Item No. **Report of the Head of Planning, Transportation and Regeneration**

Address 11 CARNARVON DRIVE HAYES

Development: Demolition of existing side/rear extension, detached garage and sheds and erection of 1 x 2-bedroom dwelling house with associated parking, involving the installation of vehicular crossover extension to front and amenity space

LBH Ref Nos: **35377/APP/2021/1523**

Rev	Date	Amendment
CLIENT		
MR. & MRS RAM		
11 CARNARVON DRIVE		
HAYES		
UB3		
PROJECT		
PROPOSED		
Site and Location Plan		
DATE		
31.08.20		
SCALE		
1:200 and 1:1250 @ A1		
DRAWN		
NA		
REV		
DRAWING NUMBER		
1182-P-020		
Neha Abayawardana RIBA		
abay.architecture@yahoo.com

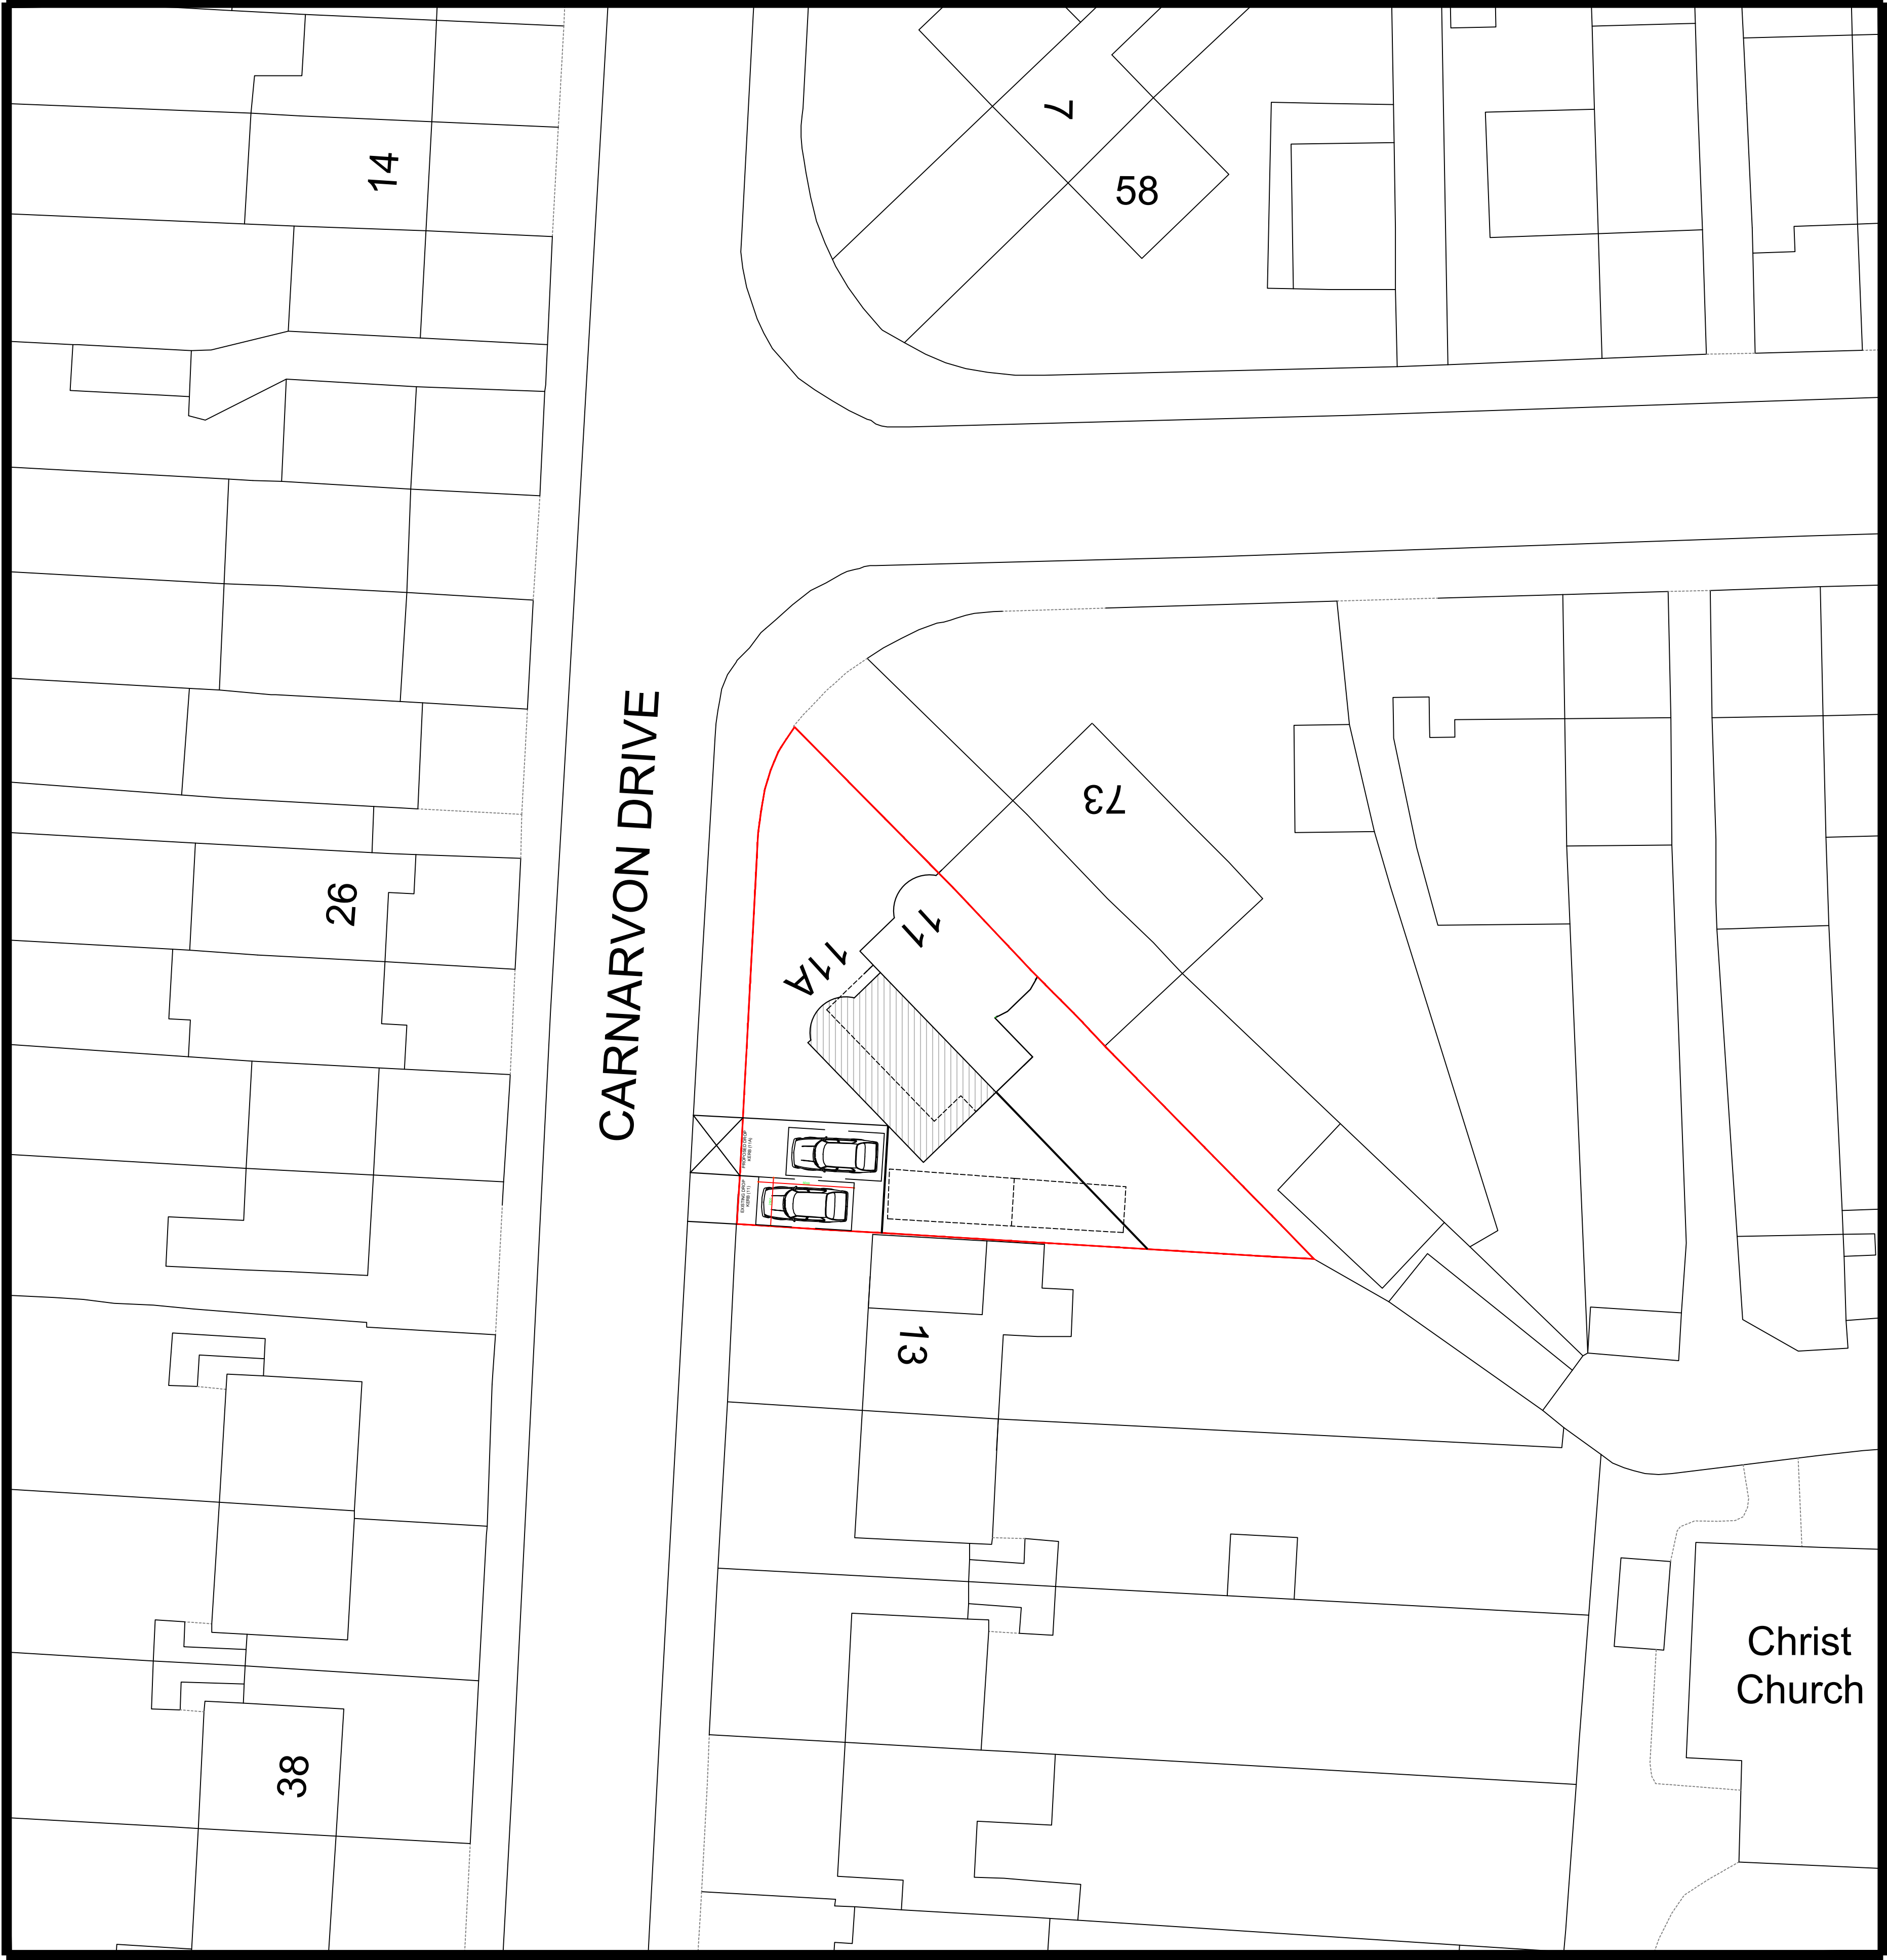
The proposed new house however, would project significantly further forward of the established return building line on Carnarvon Drive. Houses fronting this part of Carnarvon Drive are typically set back some 7m from the road to give a uniform building line. Although the existing property marginally projects beyond this building line, the proposal would result in two storey development being sited within some 2.7m of the road frontage. In such a position, the proposed dwelling would appear as an unduly intrusive and incongruous form of development detrimental to the visual amenities of the street scene and area, contrary to policies DMBH 11 and DMHB 12 of the adopted Local Plan (2020).

The Council's Tree / Landscape Officer advises that there are two highway trees in the footway outside this property; tree ref. 860 Norway maple 'Crimson King' and 861 Chanticleer Pear. The Chanticleer pear, in particular, could be affected by the development.

The position (but not the spread) is indicated approximately on plan, however no tree survey or arboricultural impact assessment has been provided.

These are valuable Council assets which contribute to the character and appearance of the area and in the absence of a tree survey and arboricultural impact assessment, to BS5837:2012, the application fails to demonstrate that the tree(s) will be unaffected by the development and should be refused. This is considered to be particularly important, given the proximity of the new living room window to one of the street trees.
